City of Portland, Maine - Building or Use Permit Application

Permit No: 09-1359	Issue Date:	CBL: 013 E012001
------------------------------	--------------------	----------------------------

Past Use: Commercial - connected to permit #09-0275 (see for use)	Proposed Use: Commercial / Install stairs and ramp from 3rd level to ground level to meet egress.	Permit Fee: \$70.00	Cost of Work: \$5,000.00	CEO District: 1
Proposed Project Description: Install stairs and ramp from 3rd level to ground level to meet egress.		FIRE DEPT: <input type="checkbox"/> Approved <input type="checkbox"/> Denied	INSPECTION: Use Group: Type:	
		Signature:	Signature:	
PEDESTRIAN ACTIVITIES DISTRICT (P.A.D.)				
Action: <input type="checkbox"/> Approved <input type="checkbox"/> Approved w/Conditions <input type="checkbox"/> Denied				
		Signature:	Date:

ELEVATION @ GRADE  
TO FIRST FLOOR ROOF  
LANDING

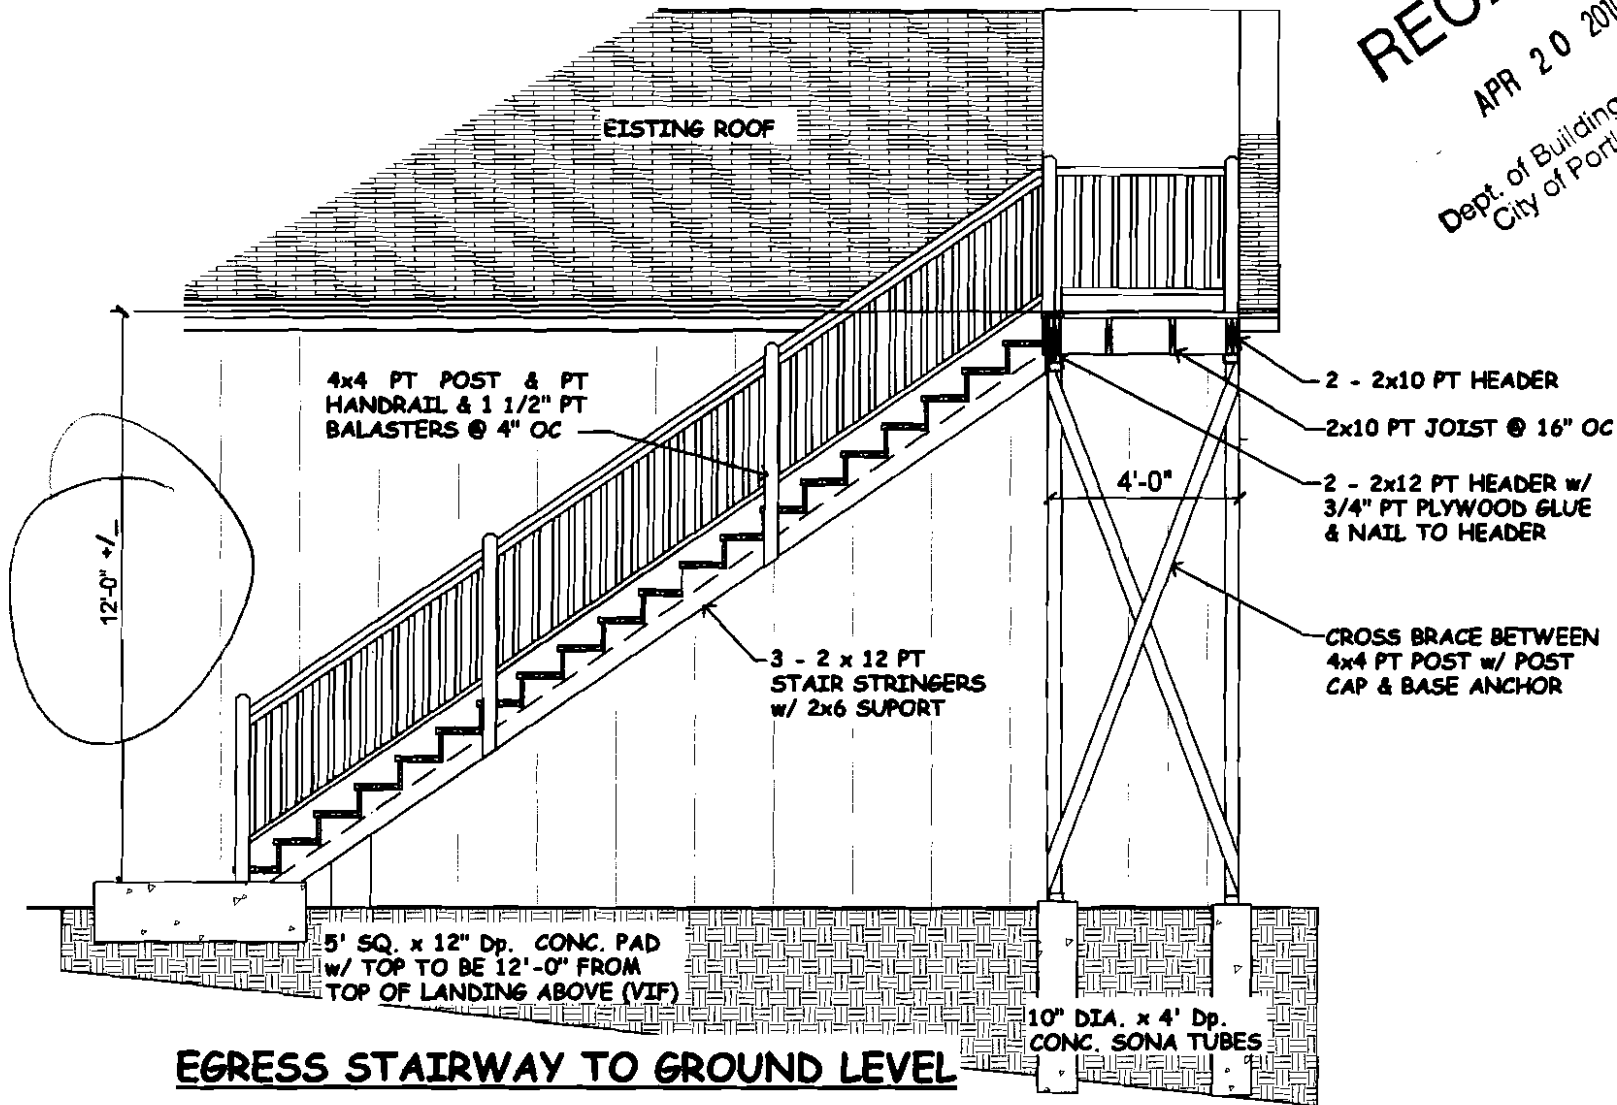
- 1) Elevation of the final stairs to grade shows 12', if more an intermediate landing will be required
- 2) Application approval based upon information provided by applicant, with revisions dated4/20/10. Any deviation from approved plans requires separate review and approrval prior to work.

4/30/2010-jmb: Spoke to Jim M. About the 12' height to grade, he thinks it is less, but will notify if more and may have to do an intermediate landing, ok to issue
